## KITTITAS COUNTY COMMUNITY DEVELOPMENT SERVICES

**RE: Transmittal of Comments Mostofi Setback Variance (VA-16-00001)**

VA-16-00001

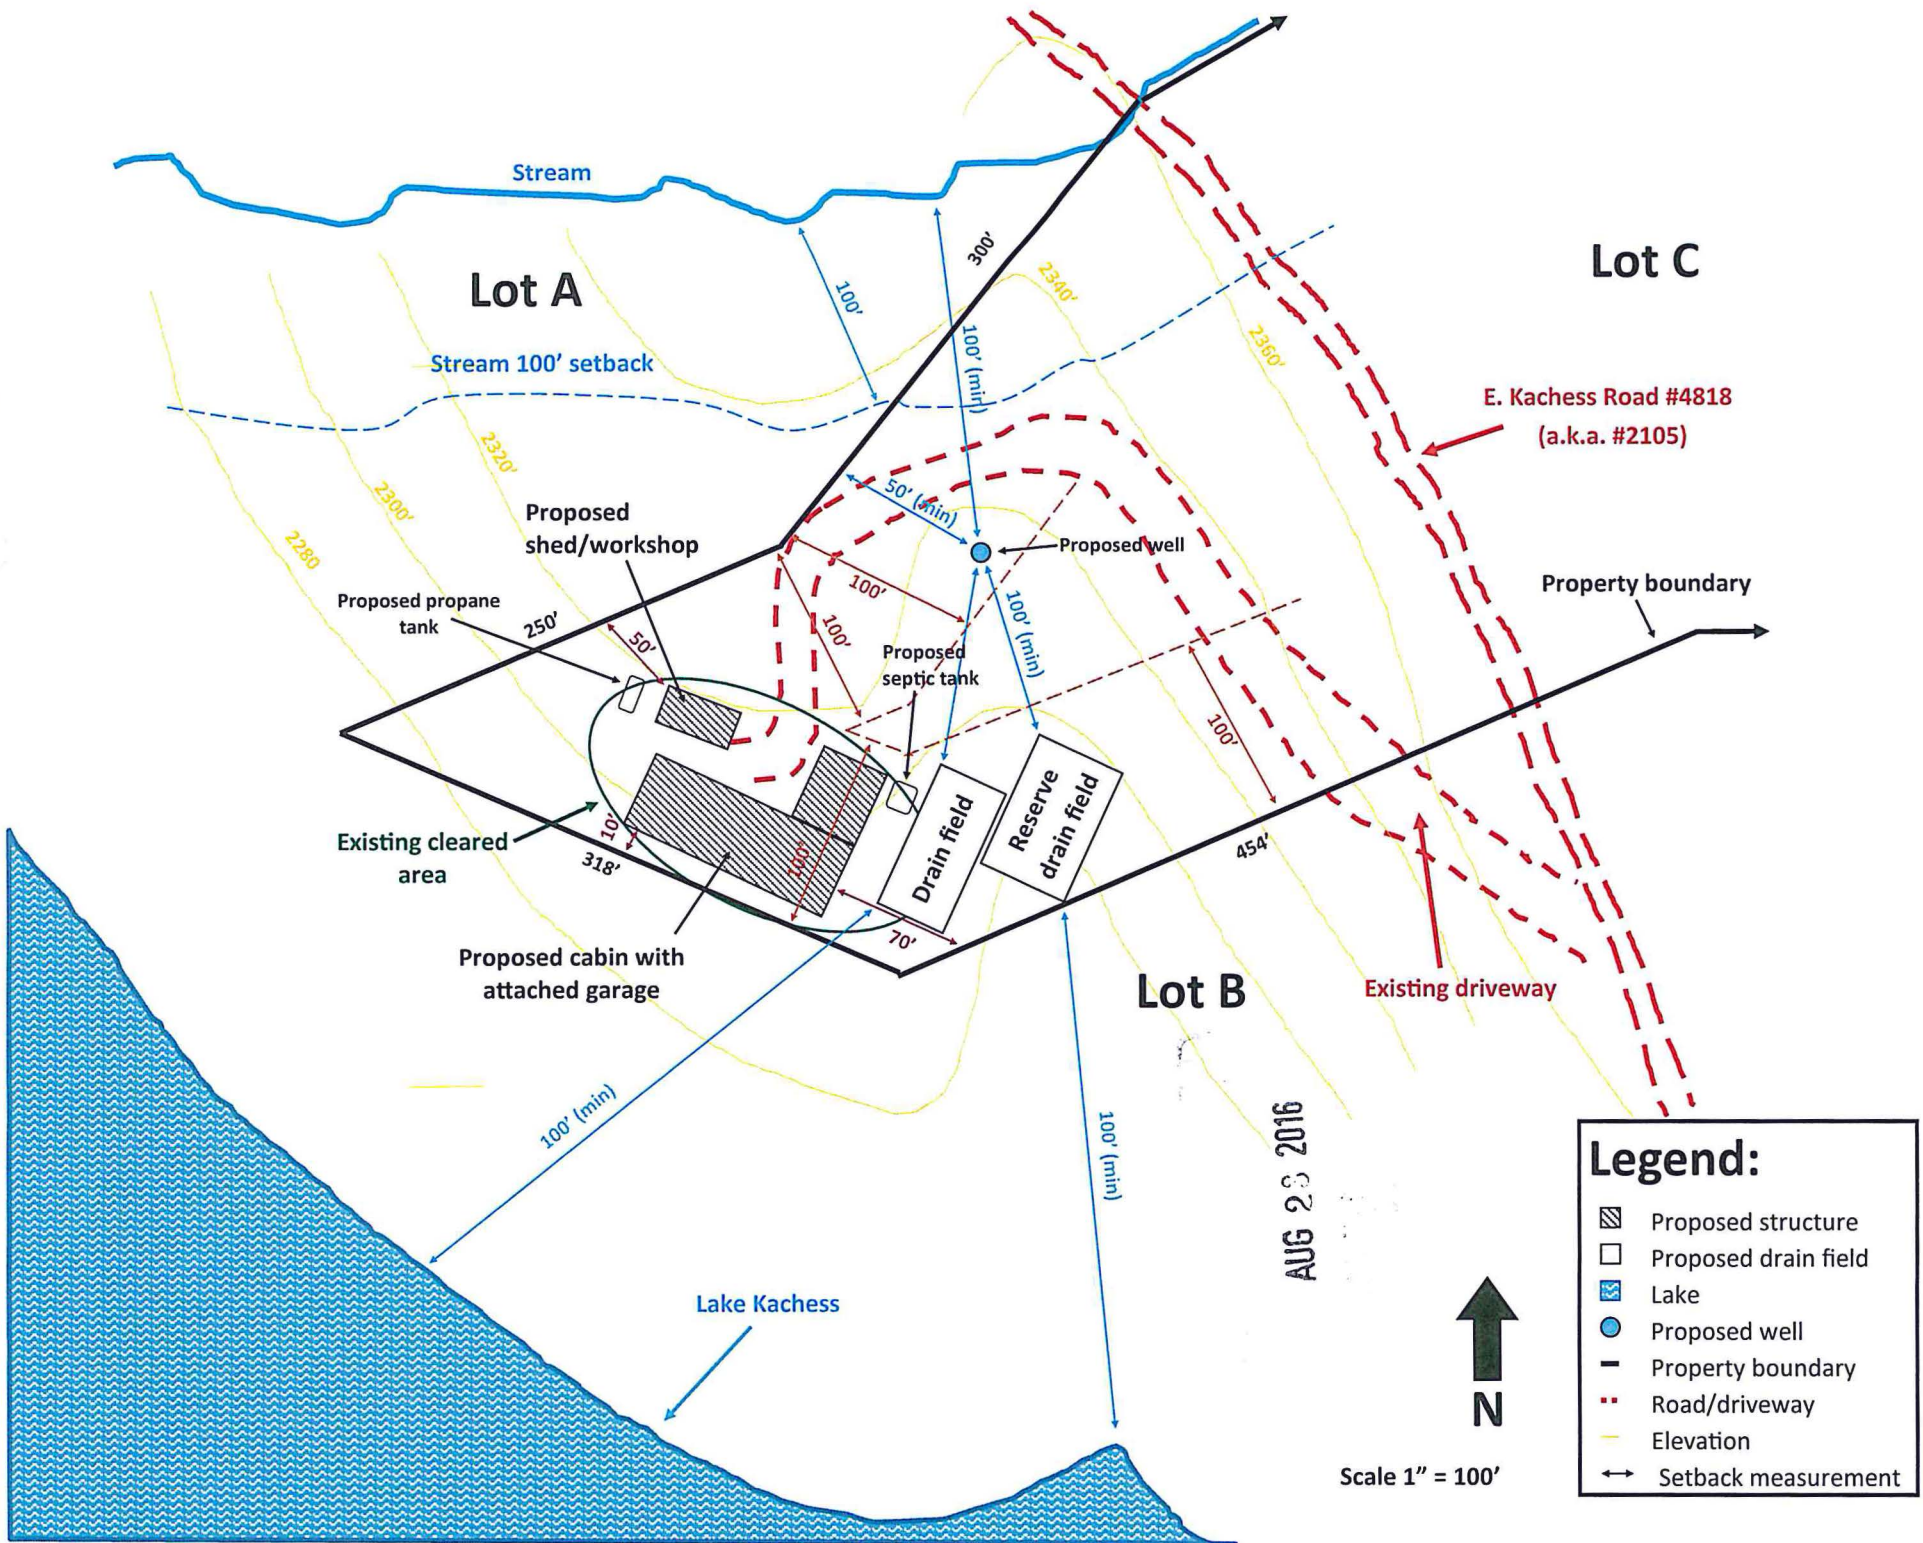
My only concern on this property is the grade. Getting a well drilling rig onto the property may be challenging and a drainfield cannot be installed on slopes greater than 30%.

Within the area proposed for building, the perennial stream to the north of the building site is fish bearing and given its close proximity to Lake Kachess could have potential for use by a variety of fish species, including Bull Trout, a listed species. Thus, WDFW requests that the 100 foot minimum buffer for the stream and the shoreline be left in place. These are the main concerns that WDFW has with this variance.

Approval of this development may require a shoreline variance permit if any development (including any appurtenances such as garages or sheds) occurs within the 100-foot setback from the OHWM of Lake Kachess or within required buffers from wetland areas. The project will require a shoreline permit exemption action if the development will occur within 200 feet of the OHWM. No mention is made regarding what the shoreline designation of this shoreline area is. The submitted map shows only that the setbacks will be "a minimum of 100 feet back" from the OHWM. A map that is adequate for shoreline review and filing purposes should show actual distances. Measurements taken via a google earth pro application show the cleared area being a little bit more than 200 feet from the visible lake level. The managed Lake level will be lower in elevation and below the OHWM due to wind and wave action. It takes a foot or more of water underneath large woody debris to move it. Therefore, the OHWM is typically higher in elevation than the debris line.

The aerial photo provided by the County for review appears to show low wet areas underneath the canopy of the trees adjacent to the Lake. These low wet areas are located toward the proposed development area. Therefore, the OHWM may extend further landward than the existing debris line toward the proposed house. In addition, the closest portion (perpendicular distance) of the proposed development to the Lake OHWM should be measured in order to determine whether a variance is needed.

1. The CDS Building Division has no objection for the applicant to encroach into the setback. Distance to be determined by Planning Division.
2. Due to steep slopes on the property, full geo-tech and soils report is required as well as engineered building plans.

- Any new driveway must comply with Kittitas County Code, i.e. driveway lengths over 150' are have a width of no less than 16 feet.
- All new construction must meet the Wildland Urban Interface (WUI) Code for building components and defensible space.
